Application number: 2023/90464	
What is the application for?:	Erection of extensions to form two-storey dwelling
Address of the site or building:	126, Gomersal Lane, Gomersal, Cleckheaton, BD19 4JQ
Postcode:	BD19 4JQ

User comments

Proposed Floor Plans & Elevations
Date: JAN23
Designed: RF
Scale: As indicated
Drawn: RF
Drawing No: 23-004-02
Checked: JW
Revision: -

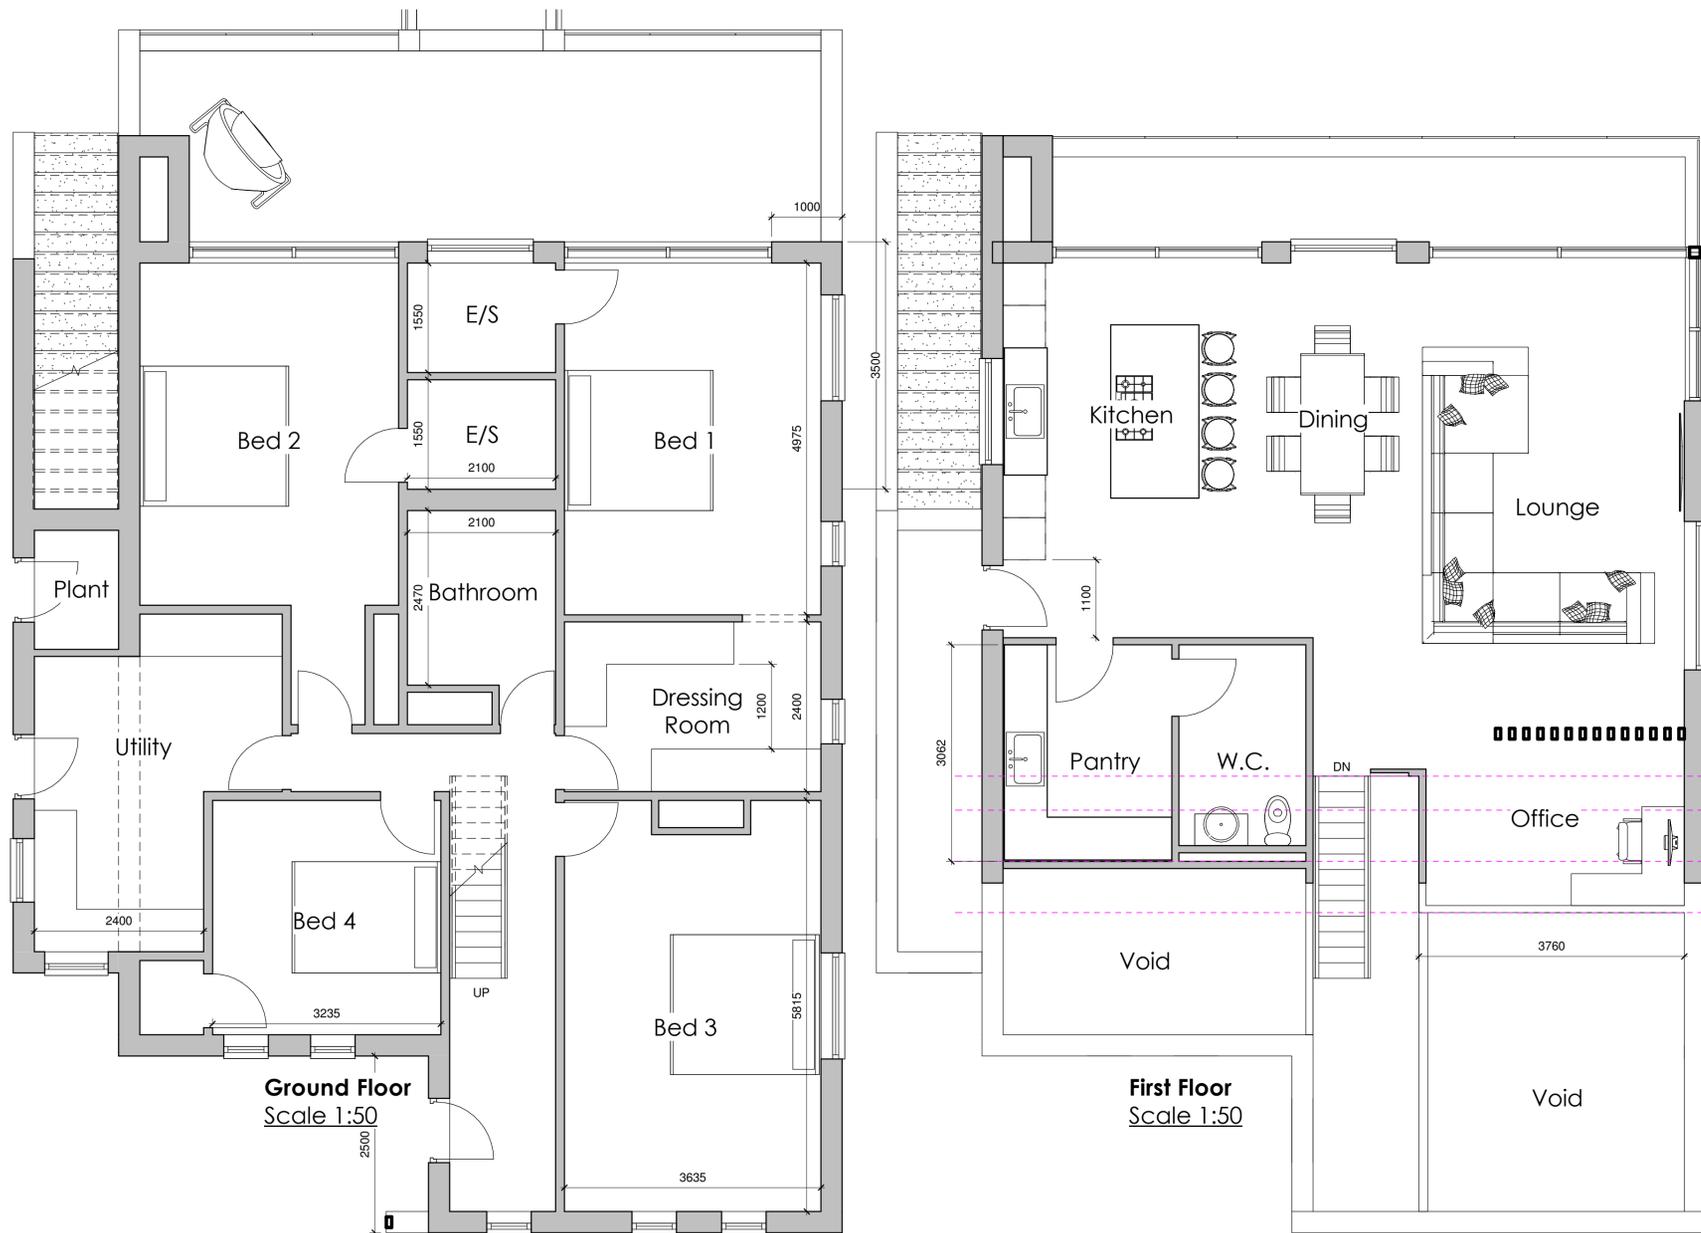
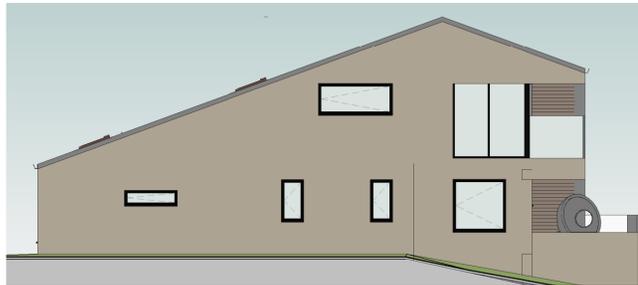
Type of comment: A general comment	
Do you wish your comments to be published on the website anonymously?	No
<p>In view of planning application 2023/90464 i wish to make the following comments.</p> <p>The 2.5m single storey extension to the front of the property will severley limit the amount of parking and turning space for vehicles at this address. The proposal is to enlarge the property and therefore one might expect the amount of traffic visiting the site may increase.</p> <p>Traffic accessing and exiting this site do so on a very narrow part of Gomersal Lane. The single storey front extension part of the proposal would inhibit sight lines of traffic travelling up Gomersal Lane. Any vehicles exiting the site would also have hindered sight lines due to the single storey extension. This could have a detrimental impact on highway safety on this part of Gomersal Lane.</p> <p>Highway safety would be impacted greatly during construction of the proposed application as there is not sufficient room for delivery vehicles to access the site properly. Any delivery vehicles would therefore have to unload on Gomersal Lane. Given the narrowness of the lane at this point , traffic would be blocked in both directions , as would the driveways of the adjacent properties, thereby preventing homeowners leaving or entering their driveways during this time.</p>
